Application No: P/171/21/DOC
Site Address: Rear of Inglenook Hotel 253-255 Pagham Road Pagham PO21 3QB
Description of works: Approval of details reserved by condition imposed under ref W/4001476 (P/58/19/PL) relating to Condition Nos 10 - proposed location of one fire hydrant or stored water supply, 12 - soft & hard landscaping, 14 - materials & finishes and 15 - boundary treatments.

Thank you for your internet representation made on 15th January 2022 which has been recorded as an objection with the comments as follows:

INGLENOOK PROPOSED FIRE MAIN SKETCH

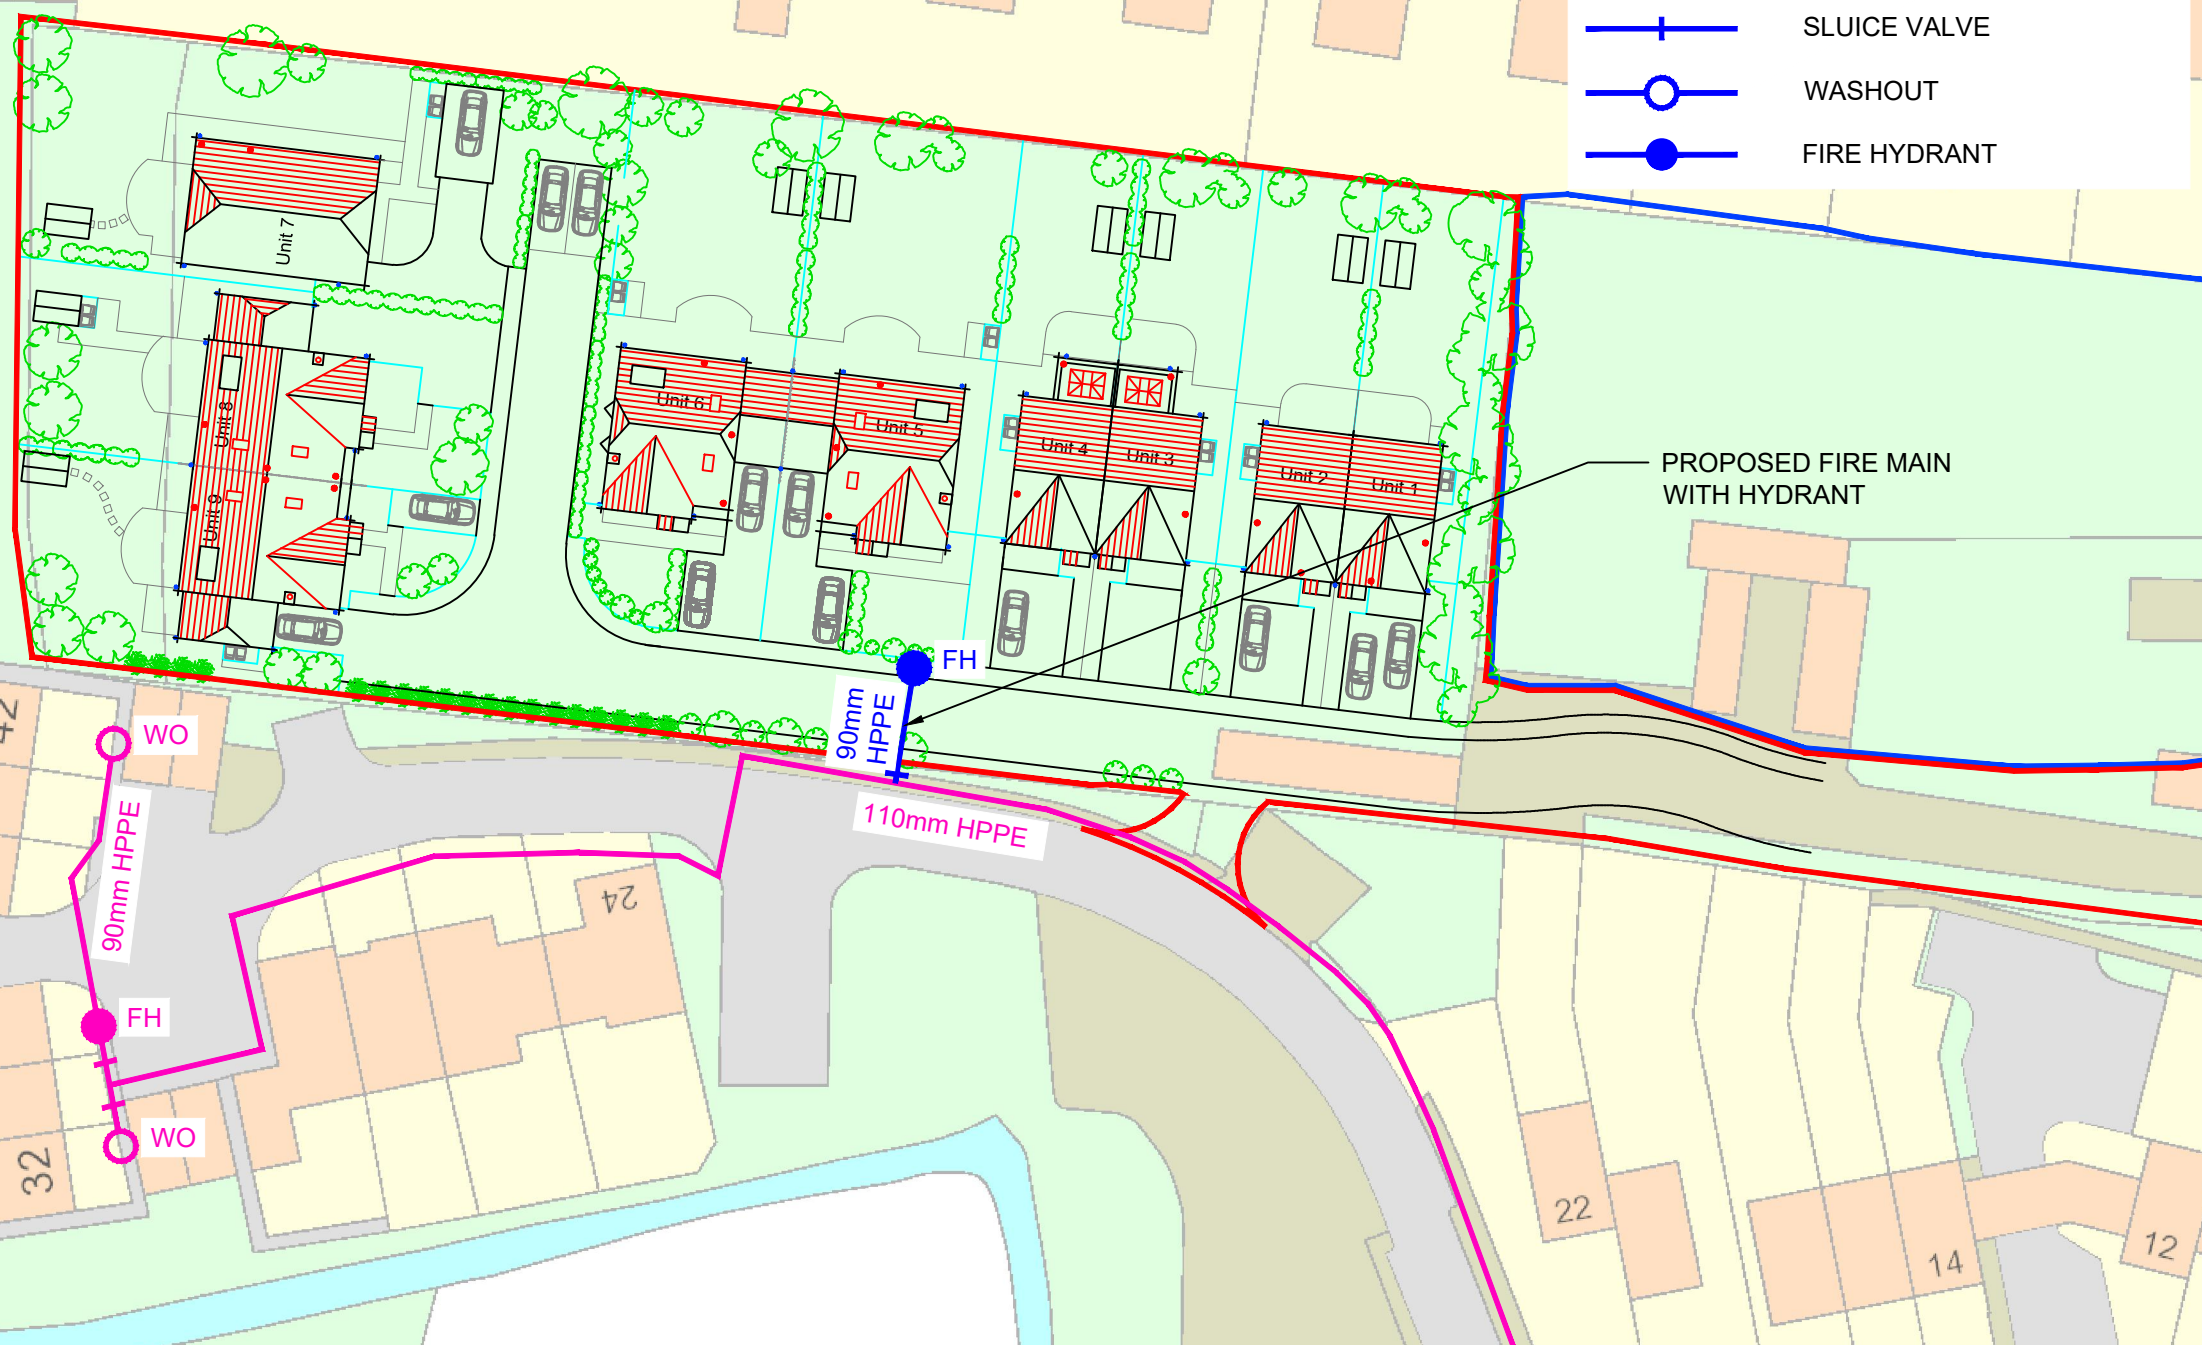
I object to this application on the grounds that there is a high pressure fire hydrant ..175 ml...situated metres from the site behind the Inglenook...the original owners of this site...The development already has an adequate supply of water...which it has been using during the build...This isn't an easement issue for maintenance.....this is yet another example of cost cutting by trying to use the facilities on this privately owned and funded three year old estate....We are not allowing access to our site , by this developer or instructions from them...I feel that you haven't been correctly informed as to ownership of our land....We are all individual shareholders of Spinnaker View..
